DECISION DELEGATED TO HEAD OF PLANNING

Application No: H12-0949-25 **Applicant:** South Lincs Methodist Church

Proposal: Change of Use, Conversion & Extension to Create a Single Dwelling

Location: Lutton Marsh Methodist Church Guys Head Road Lutton Marsh

SOUTH ELEVATION 1:100

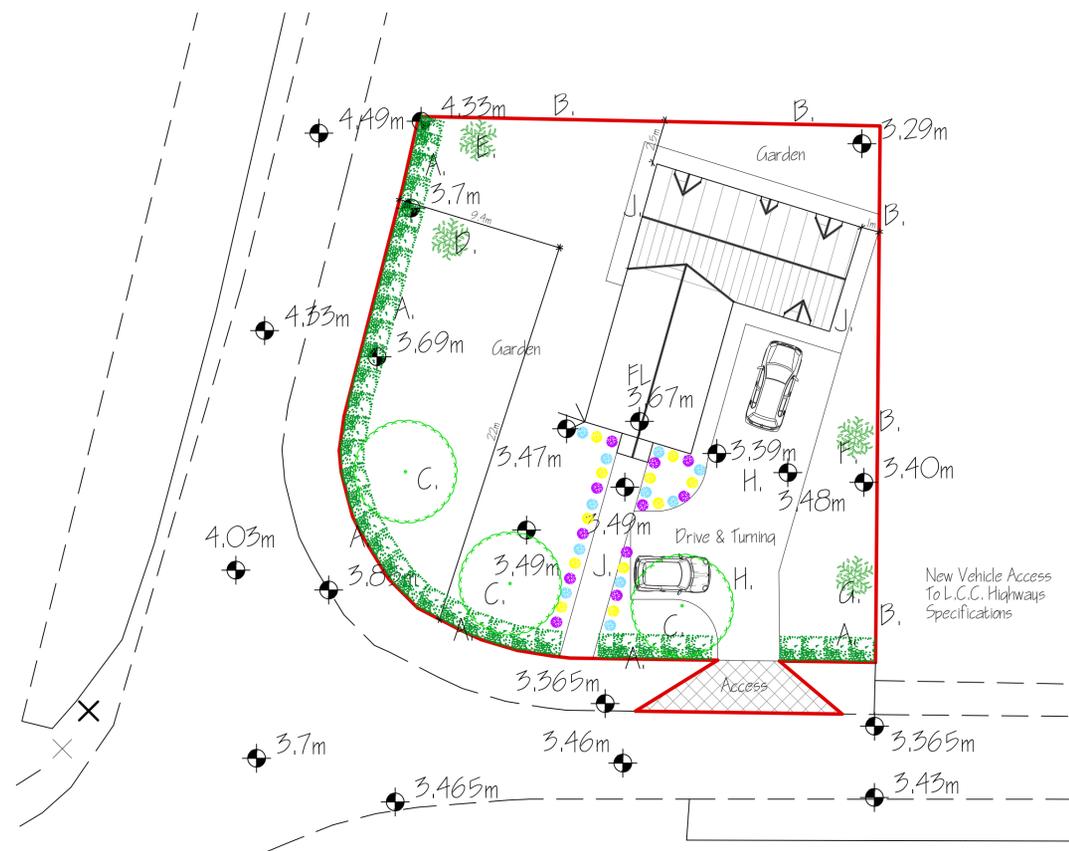
A notably large extension has been proposed within this submission to allow for a conversion to take place. The extension would project from the rear elevation by 6500mm and from the side by 4200mm, to have a total length of 10500mm. The height of the extension proposed would be 5900mm (ridge), with an eaves height of 4000mm.

In this instance, the proposed rear and side extension to form the bulk of the proposed residency would fundamentally alter the character of the building and is of such a scale as it would almost entirely crowd out appreciation of the original building. Per para. 216 of the NPPF above, a balanced judgement regarding the scale of harm is required. In this instance, I consider that the proposal neither conserves nor enhances the NDHA or its setting and therefore that the harm to the original building to be so complete as to represent grounds for refusal, such is its weight in the balance.

It should also be noted that the proposal also incorporates an extension to the rear of the existing built form, in order to offer the first floor accommodation. This extension is sizeable, and would amount to a 'significant extension and alteration, comprising a projection from the rear elevation by 6500mm and from the side by 4200mm, to have a total length of 10500mm. The height of the extension proposed would be 5900mm (ridge), with an eaves height of 4000mm.

The height has been reduced by 1100mm (7000mm to 5900mm) and the eaves by 300mm (4300mm to 4000mm). The overall size of the extension would be around 68sqm, whilst the existing floor space of the church is only 70sqm; which further reinforces the point that the extension proposes a significant increase, as it seeks to enlarge the building by almost the same size as the existing built form. Without this extension, the church is not able to be converted; therefore, the proposal fails to meet criteria 1.

As outlined above, the extension would be of a significant scale and would therefore be seen as a harmful addition that is deeply unsympathetic to the character and appearance of the modest church. The extension would dominate the building and thus cause harm in this regard.

The extension would project from the rear elevation by 6500mm, and 4200mm from the side; whilst having a total length of roughly 10500mm. Further to this, the extension would create an additional floor for habitation and would therefore sit notably above the existing ridge height of the church; albeit at a lower height than the previously refused scheme on site. The height of the extension sits at around 5900mm with the eaves being 4000mm.

Although the height has been lowered, the proposed extension would still fail to appear subservient or subordinate and paired with the significant bulk of the extension, it is considered to be constitute a harmful addition; taking away from the existing design of the building, which holds historic value. As outlined in the previous report, the proposed design is adversely obtrusive and offensive and is therefore at direct conflict with the SELLPs design policies and would cause impact to the overall character of the area.

Extensions to an NDHA such as this should seek to be much reduced in scale or bear as lightweight an impact upon what original structure remains on site. This may, for instance, take the form of a form of construction to the side(s) of the extant building with a glazed link offering visual demarcation between the extant and the new.

FIRST FLOOR PLAN 1:50

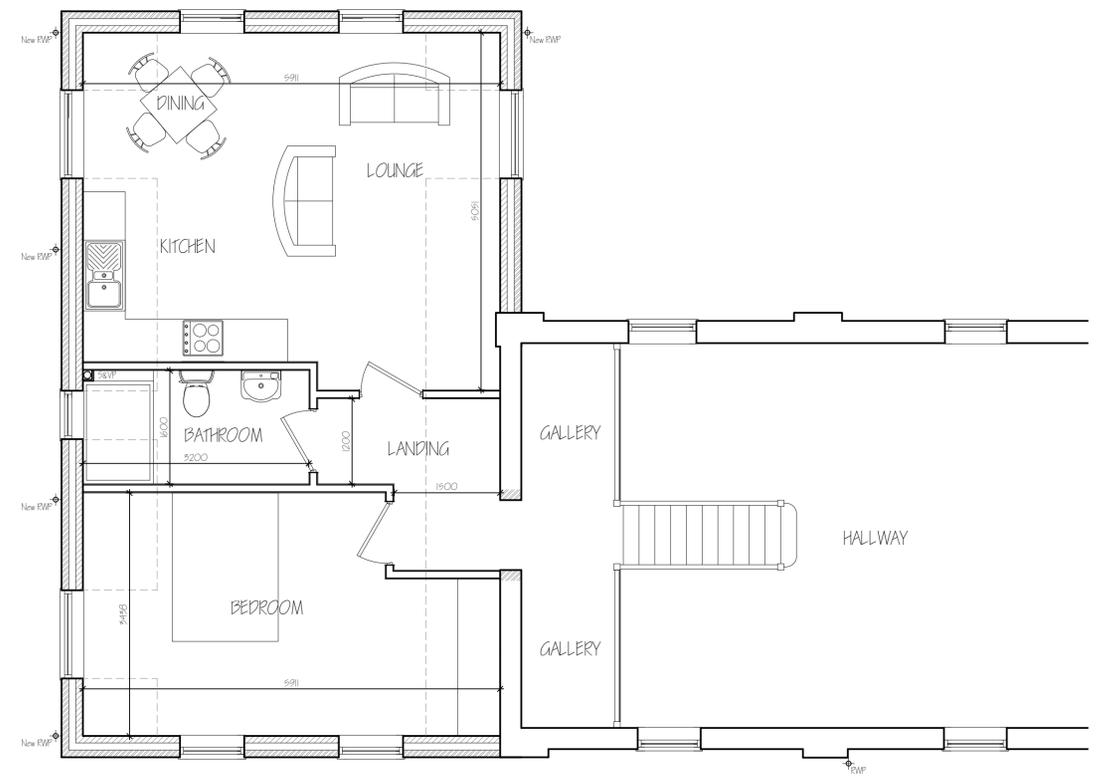
As such, in order for the proposed conversion to a residential dwelling to be acceptable, the existing church must be extended as to create a first floor. Whilst this has been proposed in this instance, such development would constitute a 'significant extension, alteration or rebuilding' and as such, would fail to accord with criteria 1 of Policy 23.

The proposal, for the conversion of the building to form a dwelling, comprises a significant extension protruding from the rear elevation, whilst also extending visually beyond the side of the existing built form, which would create an additional floor space of 68sqm.

The extant church, in its current form, has an internal floor space of 70sqm and as such, the extension proposed would enlarge the building by almost the same size as the existing church itself.
